# WINDERMERE PRELIMINARY PLAN

## E 1/2 OF SECTION 29, T13S, R65W OF THE 6TH P.M. EL PASO COUNTY, COLORADO

COUNTY FILE NO.: SP-19-003

### PRELIMINARY PLAN

**PRELIMINARY  
UTILITY & PUBLIC  
FACILITY PLAN**

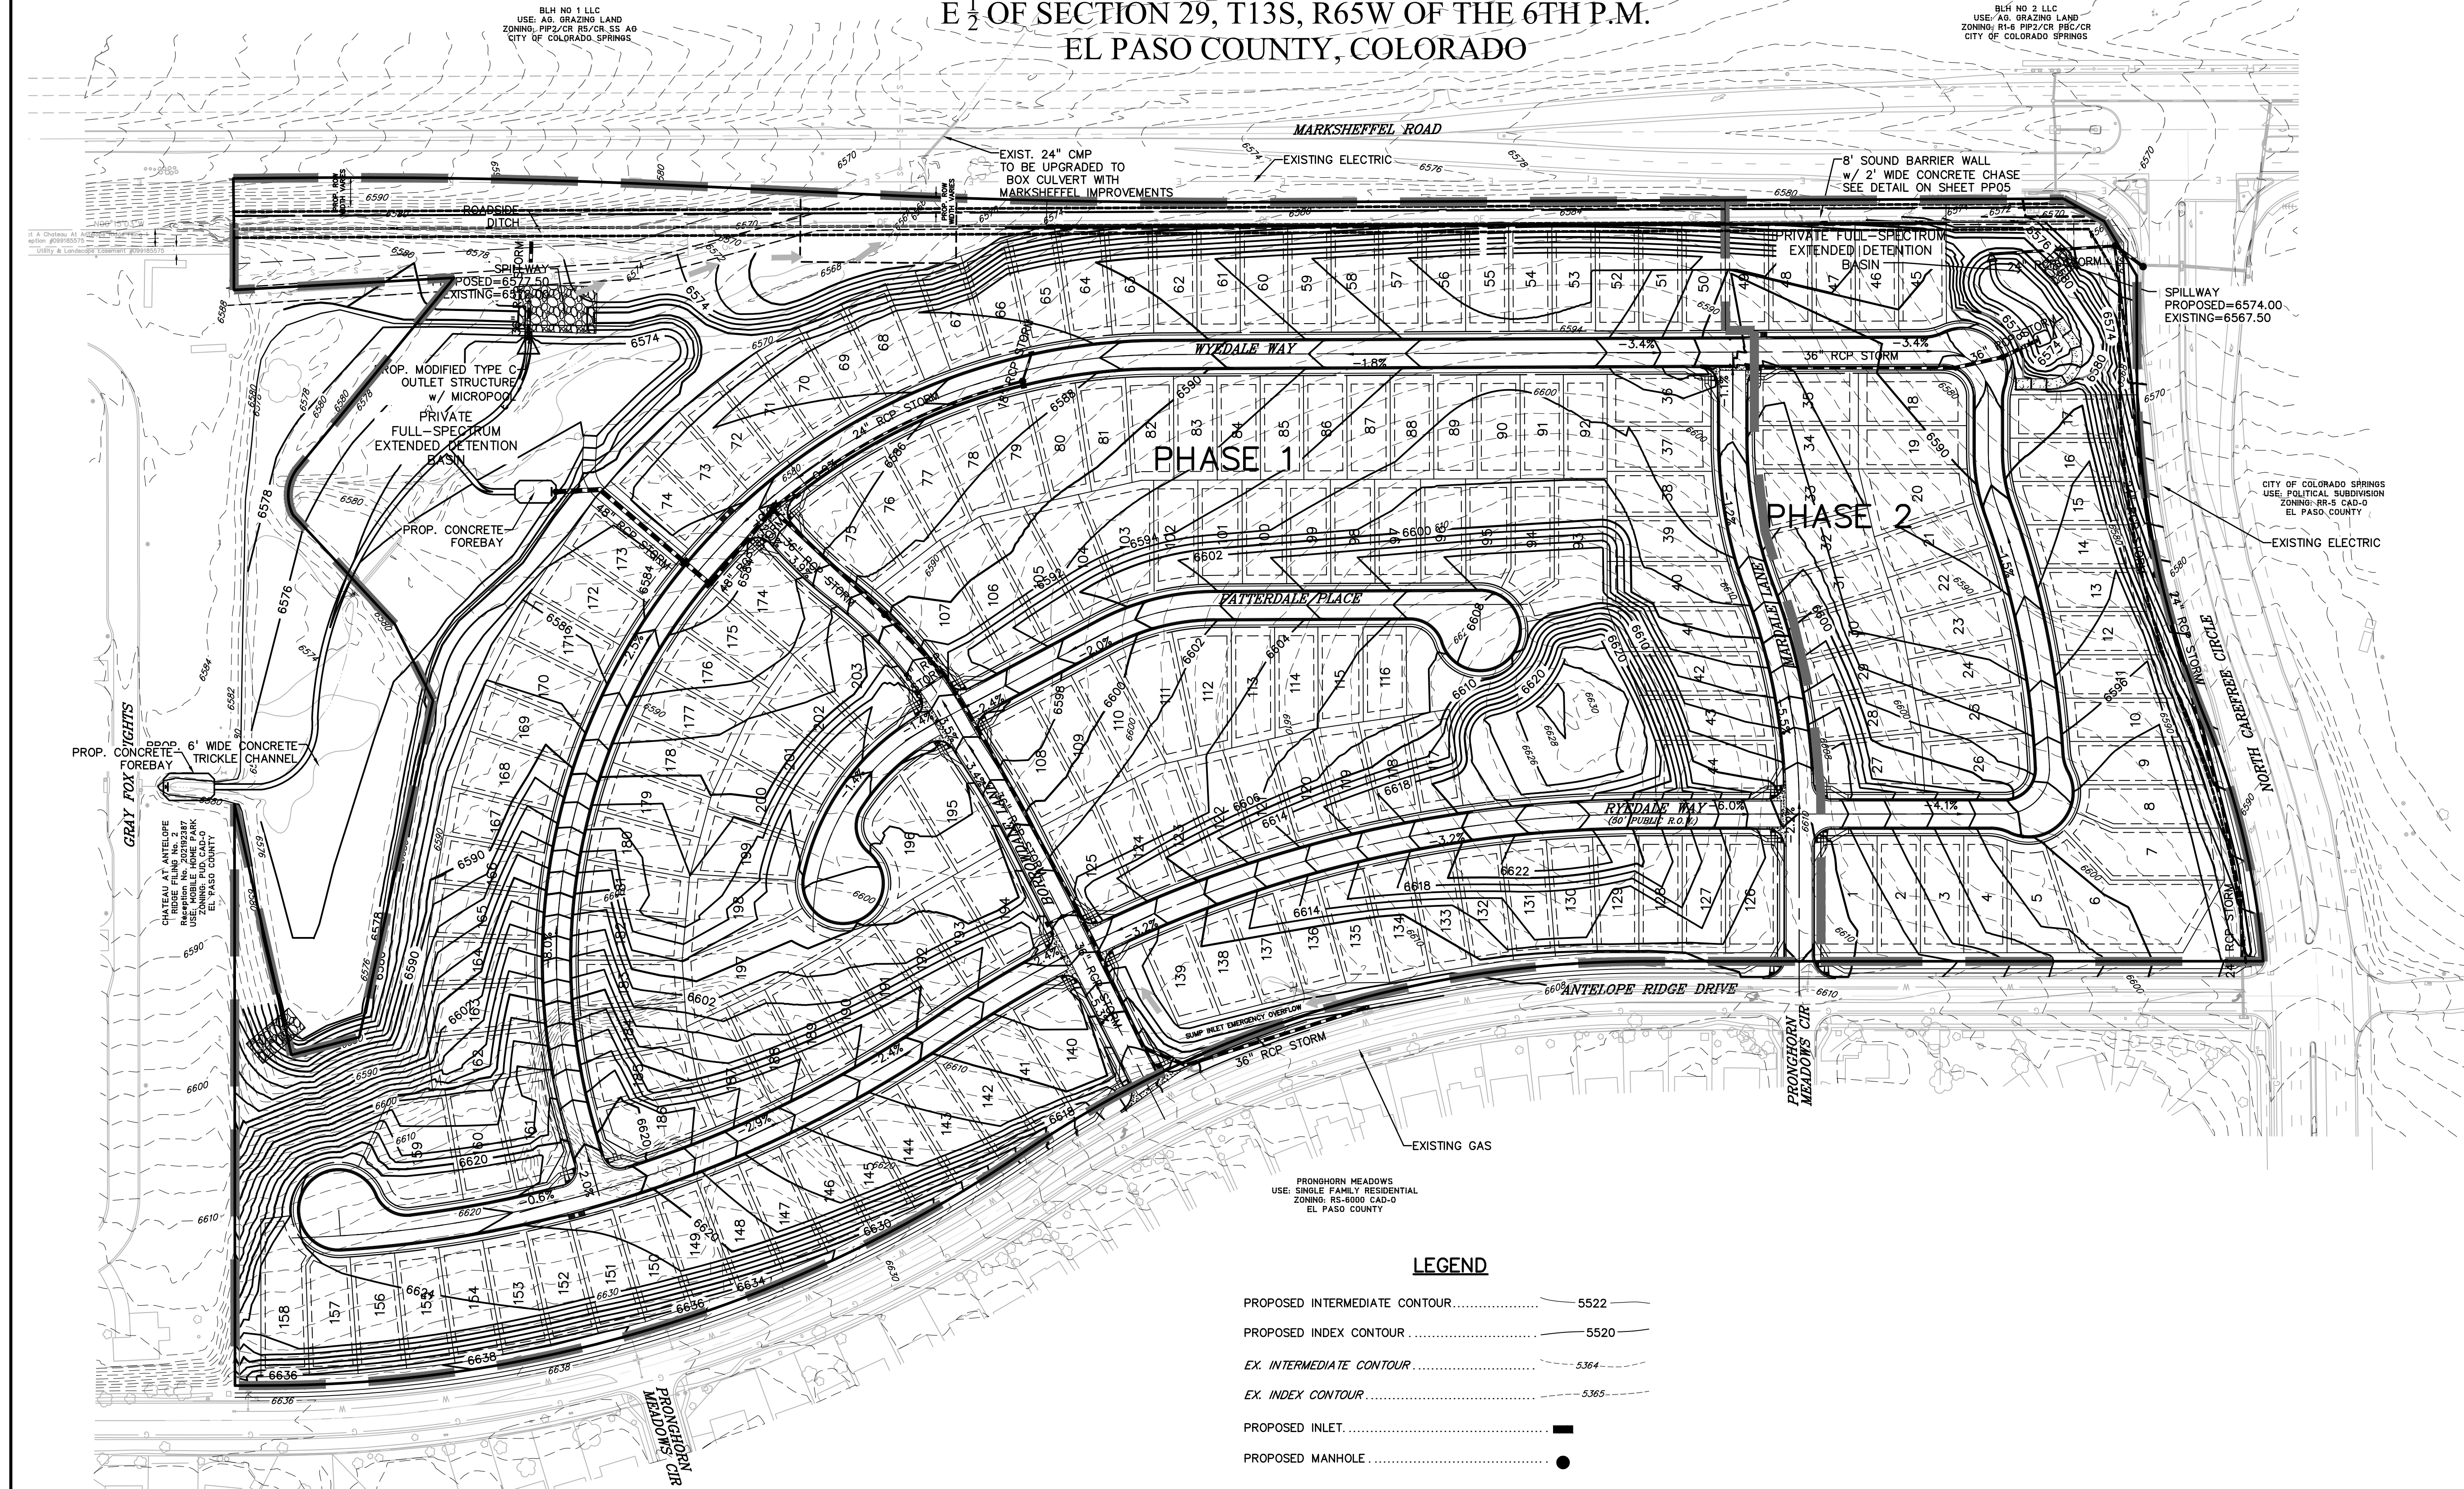
please work with Parks to achieve park lands agreement draft to receive urban PARK CREDITS, and PROVIDE A PARK AND THE DETAILS

**PRELIMINARY  
 GRADING PLAN**

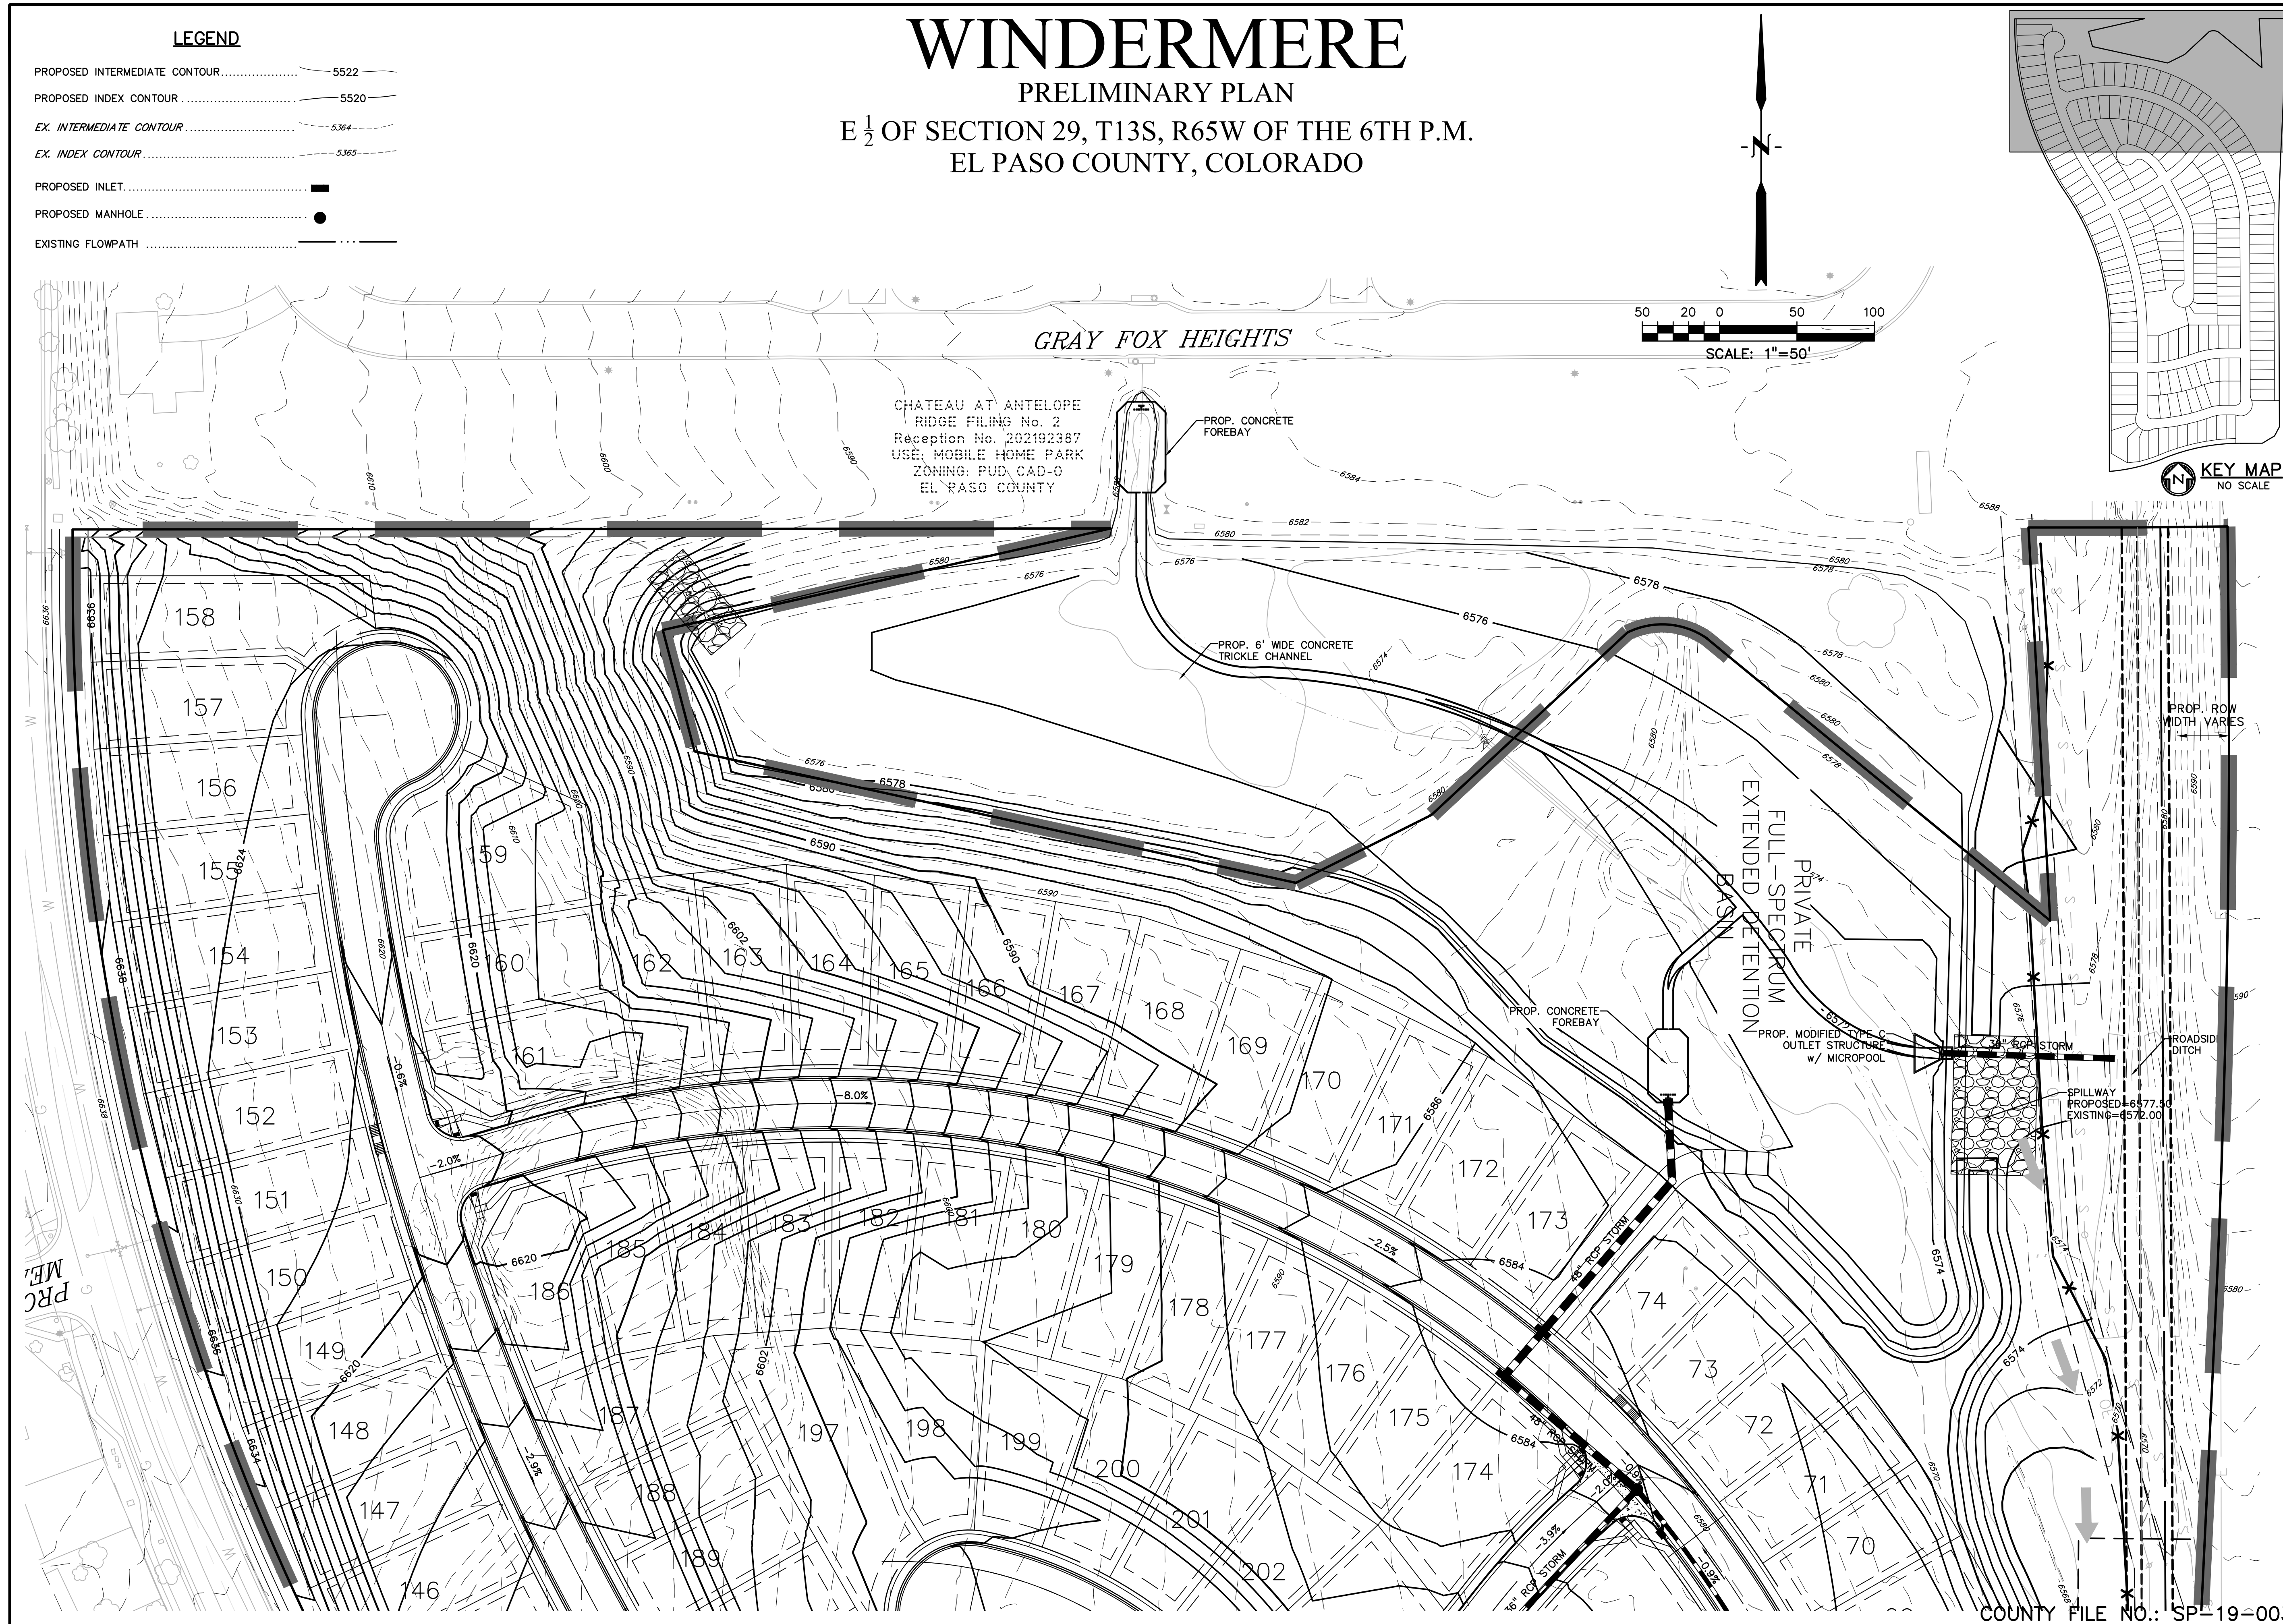
Grading in County easement not allowed:

Label all drainage facilities. An additional detail may be required.

why 2 pipes?
